# CHEROKEE METROPOLITAN DISTRICT - MOBILE OFFICES

8655 E. SWAN RD.  
 COLORADO SPRINGS, COLORADO 80908  
 SITE DEVELOPMENT PLAN - SWAN RD SITE

**MOBILE OFFICES SITE DEVELOPMENT PLAN**

SHEET NO: **DP-01**

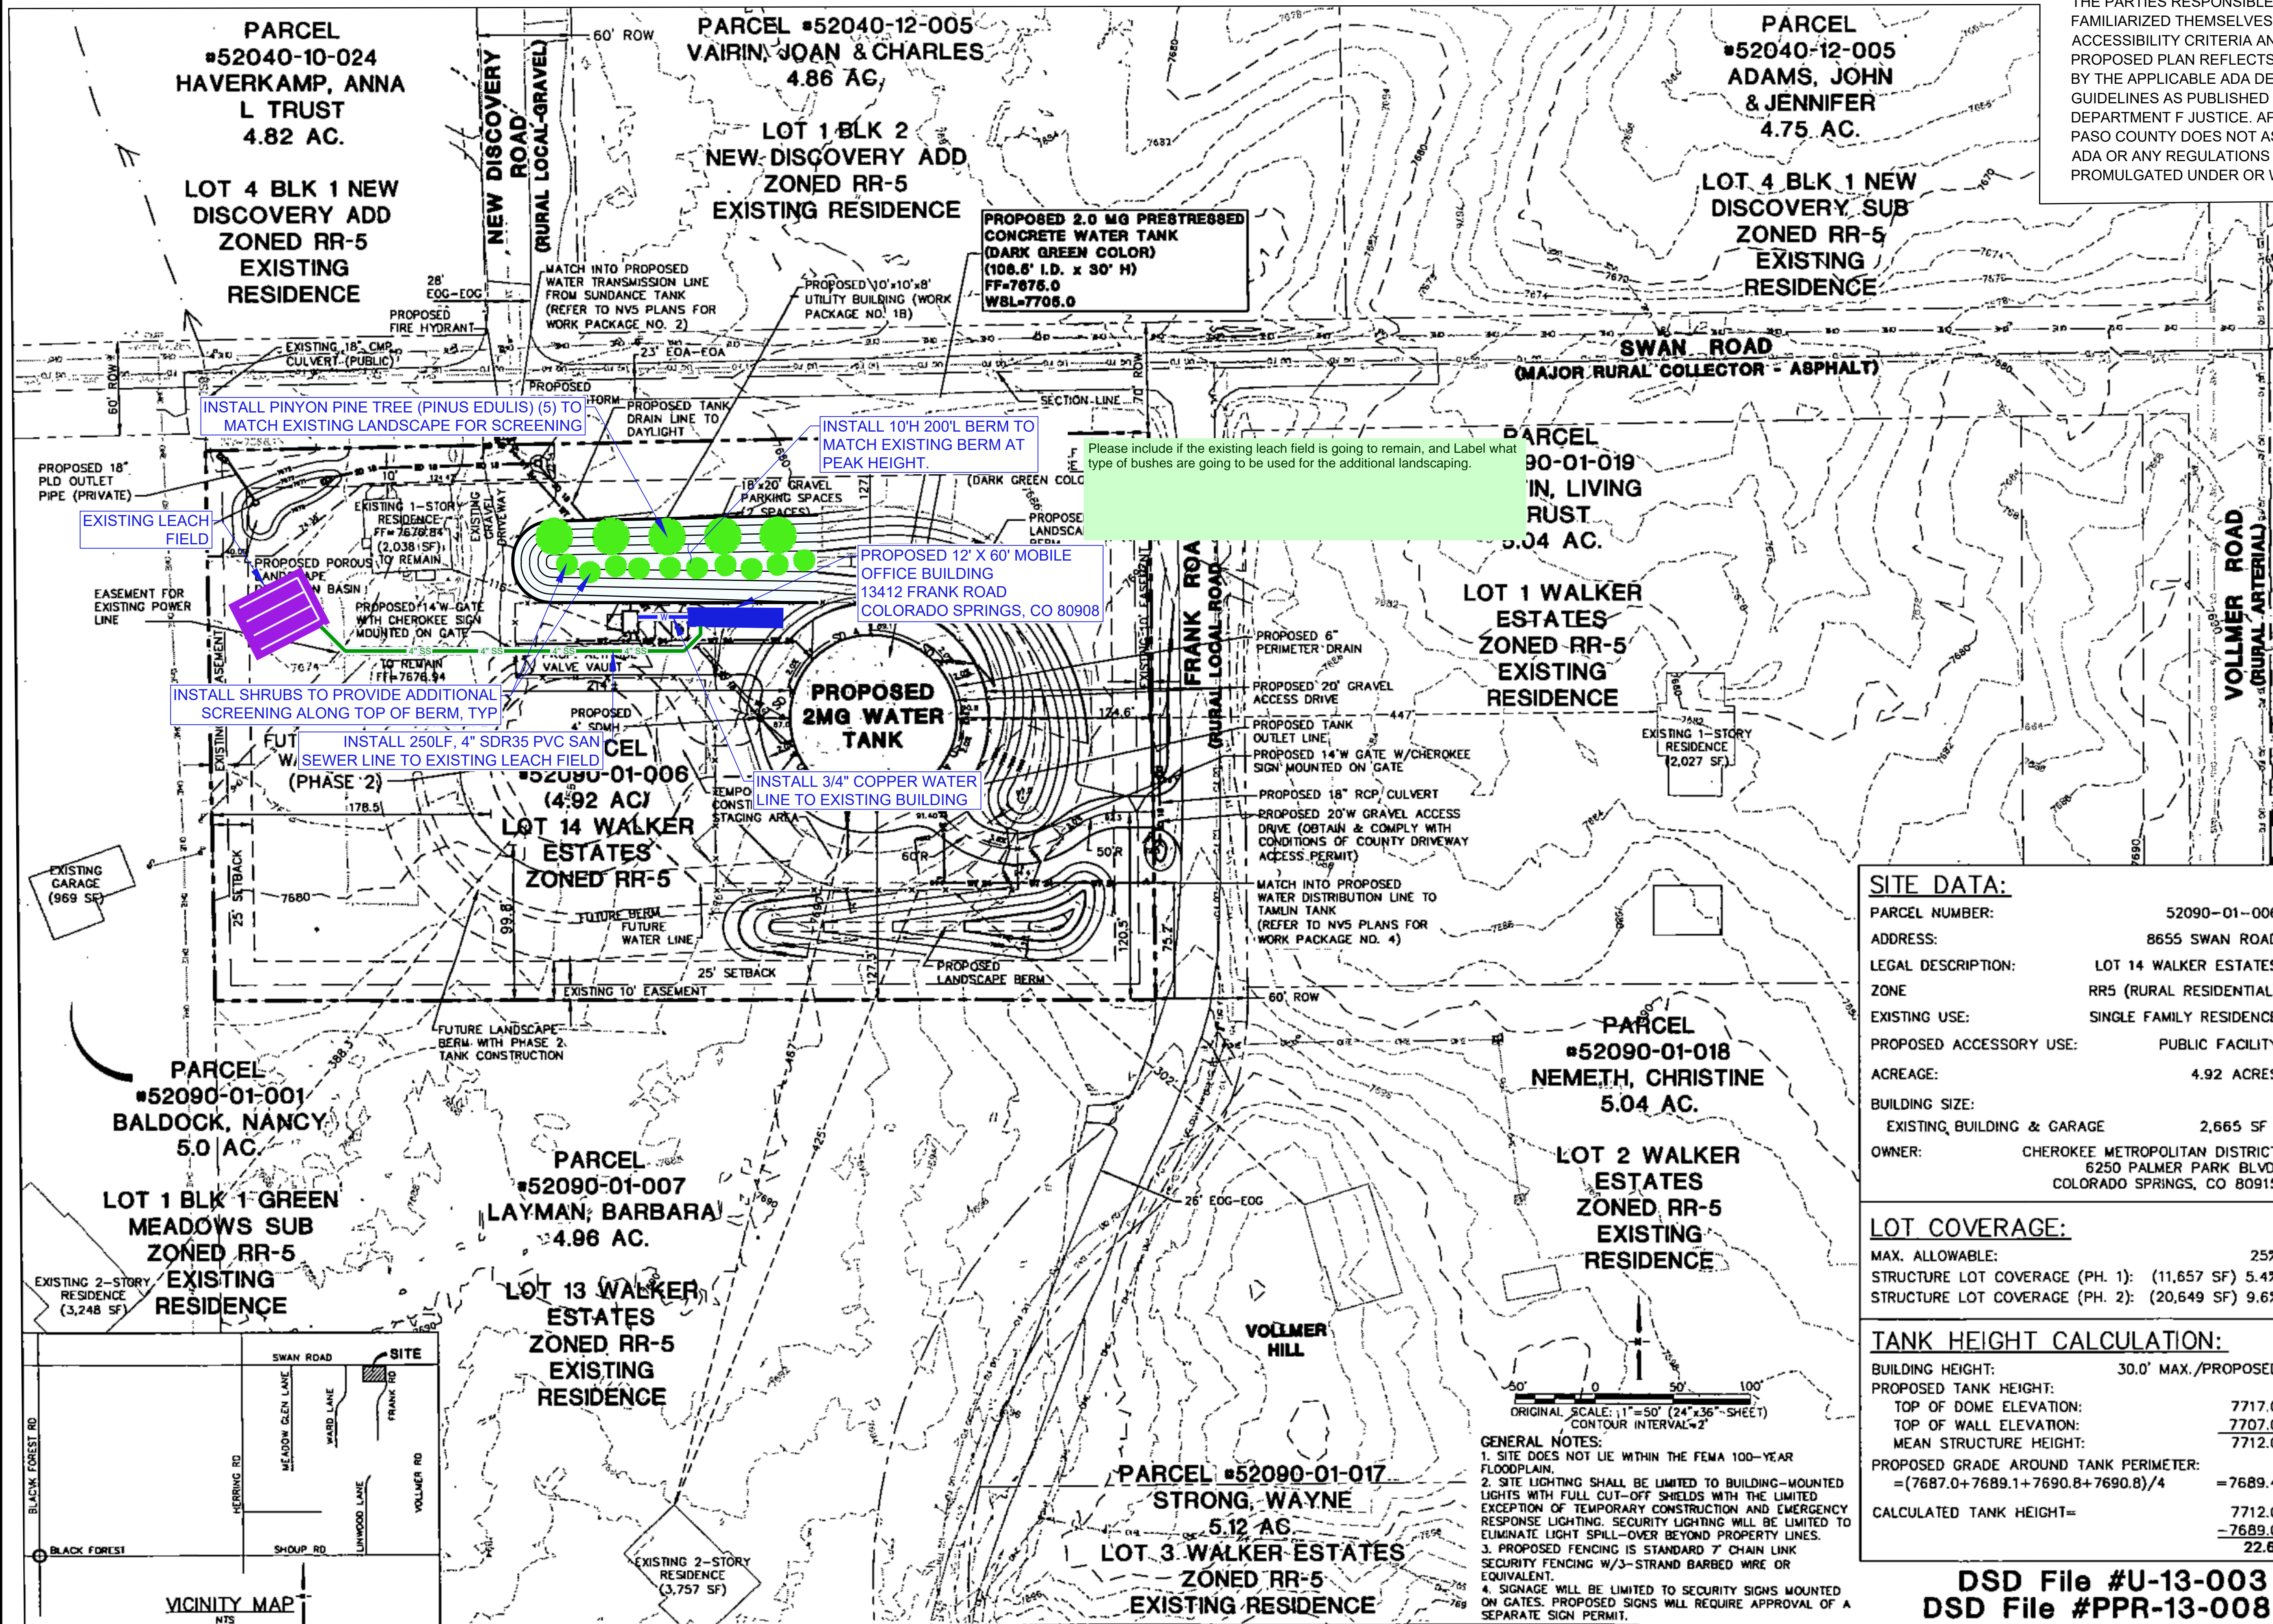
Per new county standards all site developments plans must have the following note:  
"The parties responsible for this plan have familiarized themselves with all current accessibility criteria and specifications and the proposed plan reflects all site elements required by the applicable ADA design standards and guidelines as published by the United States Department of Justice. Approval of this plan by El Paso County does not assure compliance with the ADA or any regulations or guidelines enacted or promulgated under or with respect to such laws." A separate sheet indicating ADA access routes must be provided.

Where is parking? See floor plans for floor plan layout, and address parking on site development plan
